From: Nolan, Chris <Chris.Nolan@lancashire.gov.uk>
Sent: 06 December 2017 12:21
To: Robert Major; planning
Cc: LHS Customer Service
Subject: D3.2017.1122 - Willow Spring 58 Pendleton Road Wiswell

Planning Application No: 3/2017/1122

Proposal: Discharge of condition 3 (materials), 6 (trees and hedges), 10 (details of the provisions to be made for building dependent species of conservation concern, artificial bird nesting boxes / artificial bat roosting sites have been submitted), 14 (detailed scheme for the site access off Pendleton Road) and 15 (construction method statement) from planning permission 3/2017/0504.
Location: Willow Spring 58 Pendleton Road Wiswell BB7 9BZ

Project	Willow Spring   Wiswell		
Drg title	Tree Retention & Protection Plan		
Drg nr	LYR089_M303	Drg Rev	-
Scale	1:200 @ A1	Drawn	HC
Status	PLANNING	Checked	ST

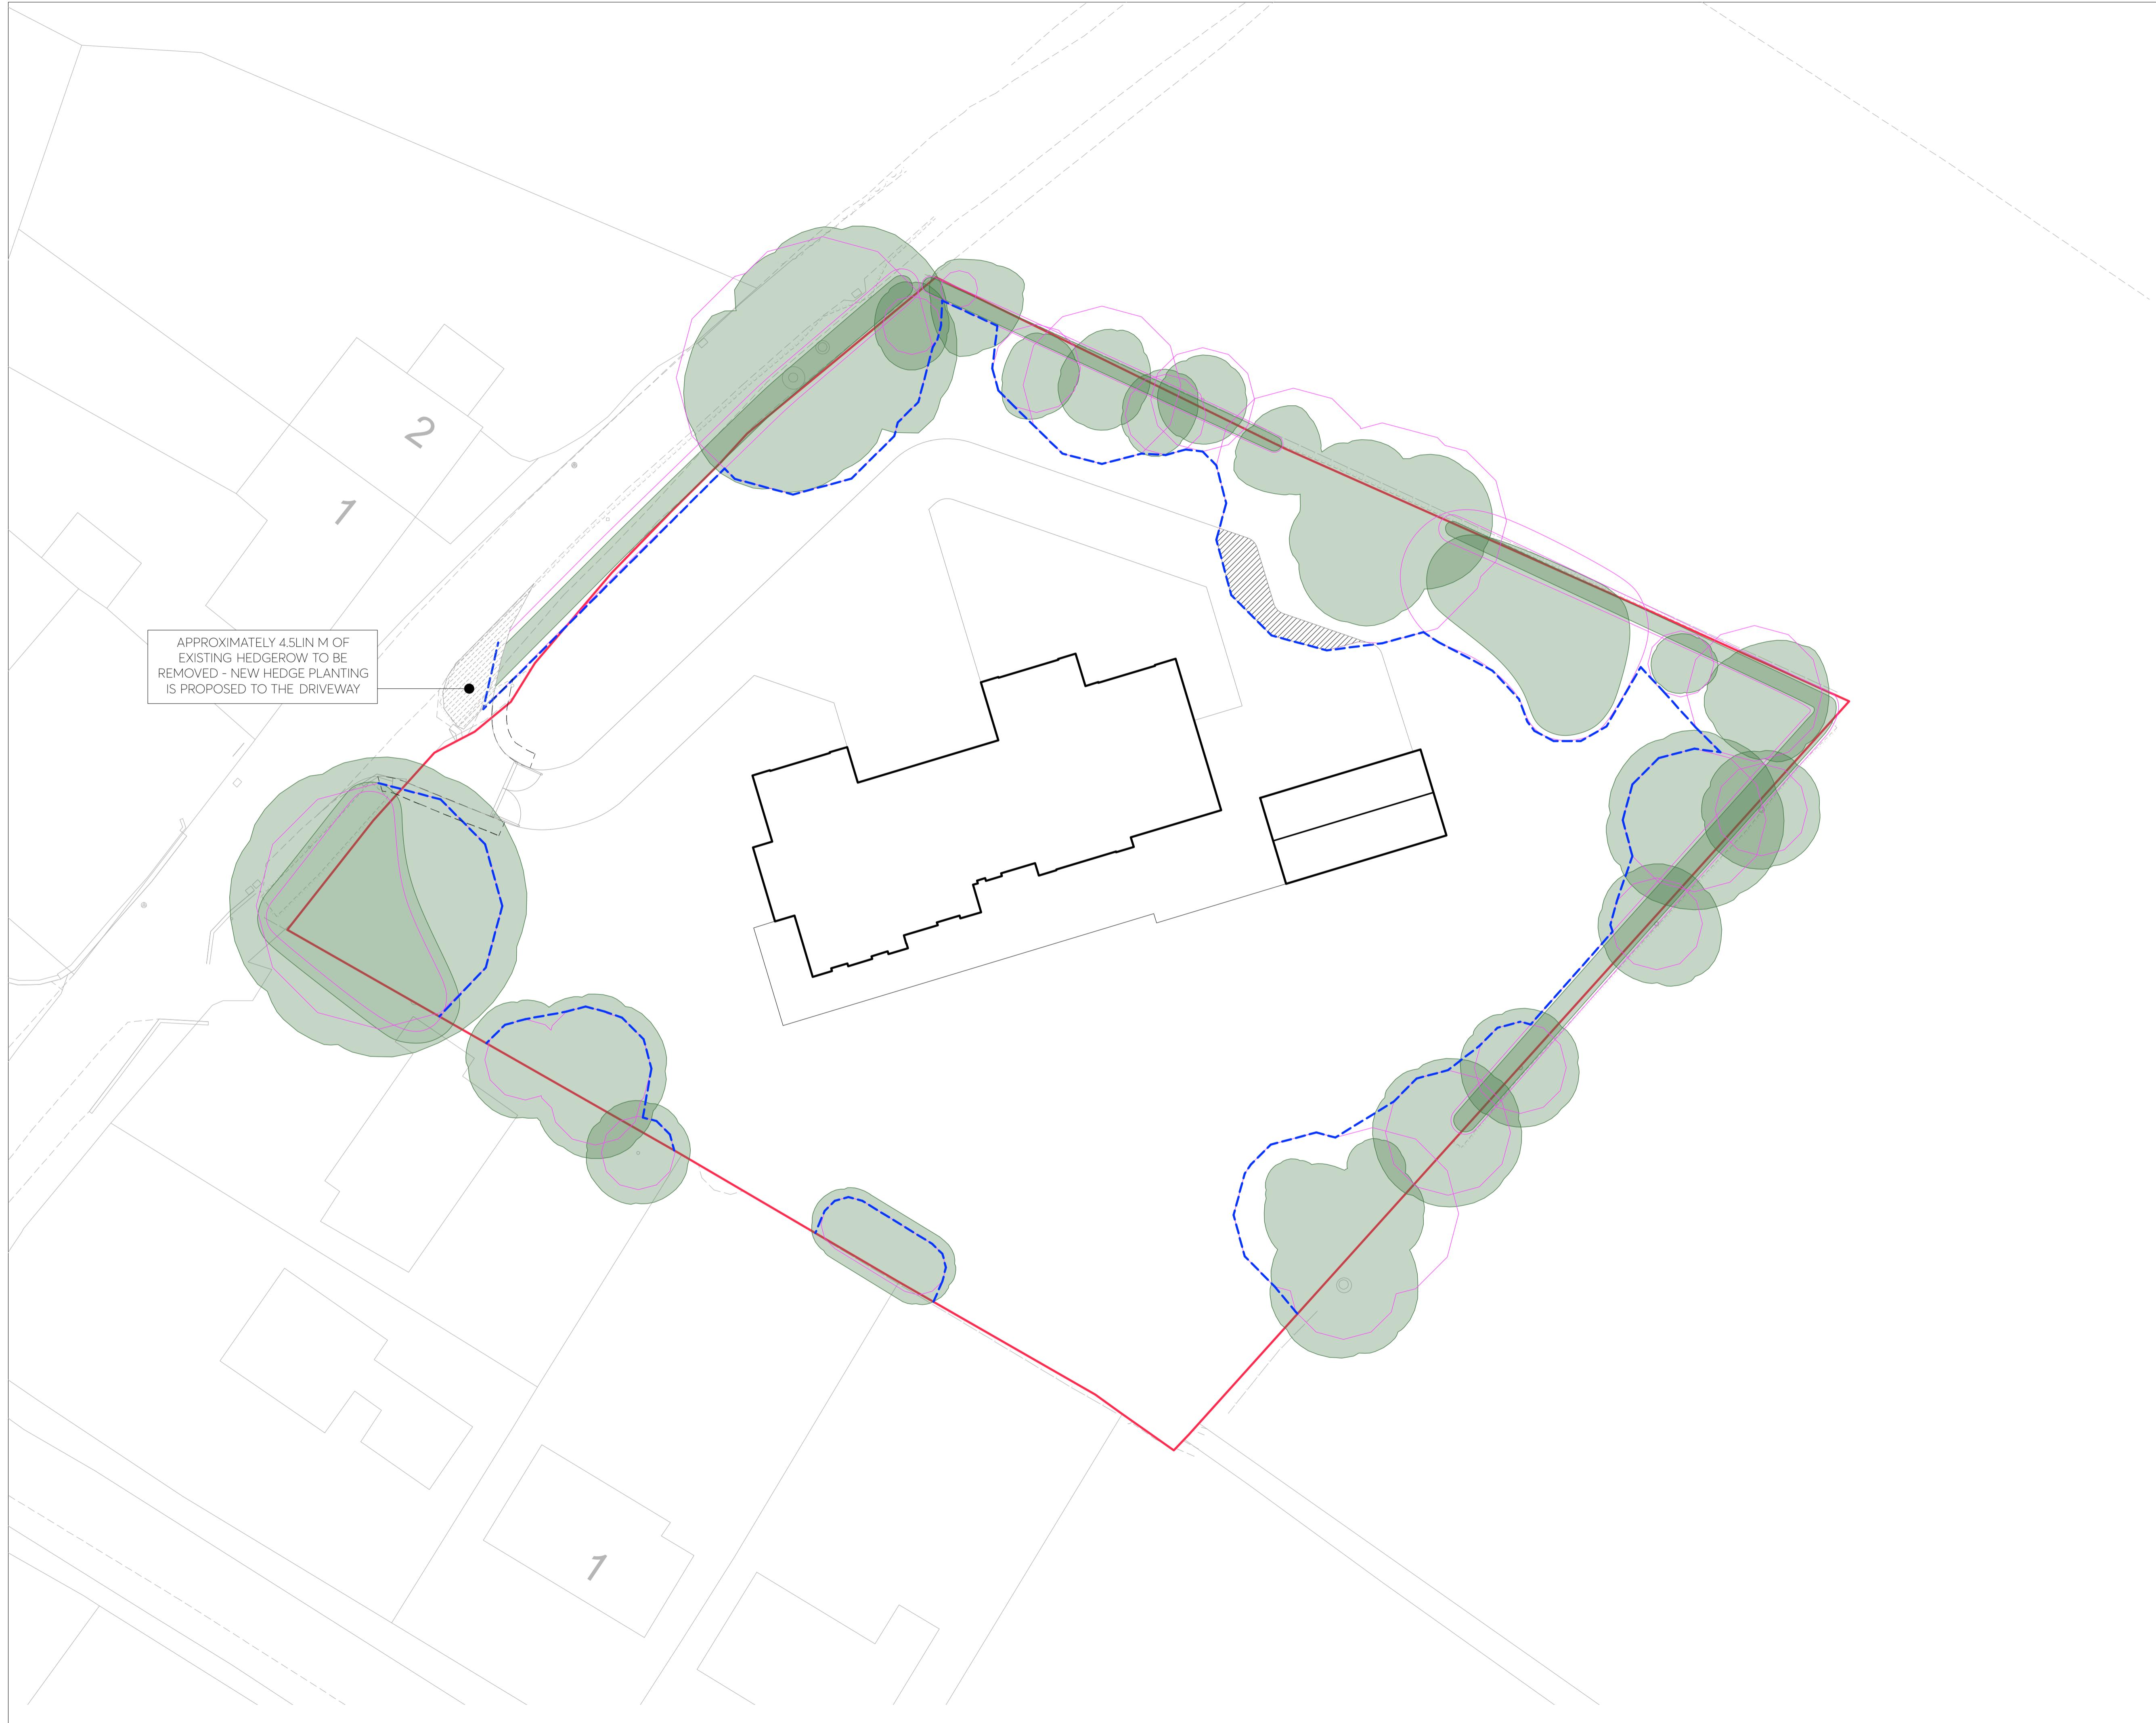
The traffic count information indicated that the 85 percentile speed on this road is recorded as 27.4mph southbound and 29mph northbound this should indicate a need for visibility splays of 37m in a north-easterly direction and 41m in a south westerly direction. The data also showed that there was only 100 vehicles per day in each direction indicating that this is a very quiet country lane. The plans indicate that the hedges will be cut back to provide a visibility splay of 25m to the north of the access point and 21m to the south of the access point. As the access point is an established facility, it is not significantly different than many other access points on Pendleton Road and the road has a very low traffic flow I am able to accept the proposed works. This move will make a significant improvement compared with the existing situation but the hedges will need to be maintained to ensure that the visibility splays are also maintained.

I would agree that once this work is completed the condition can be discharged on the understanding that the hedge will be correctly maintained to preserve the visibility splay.
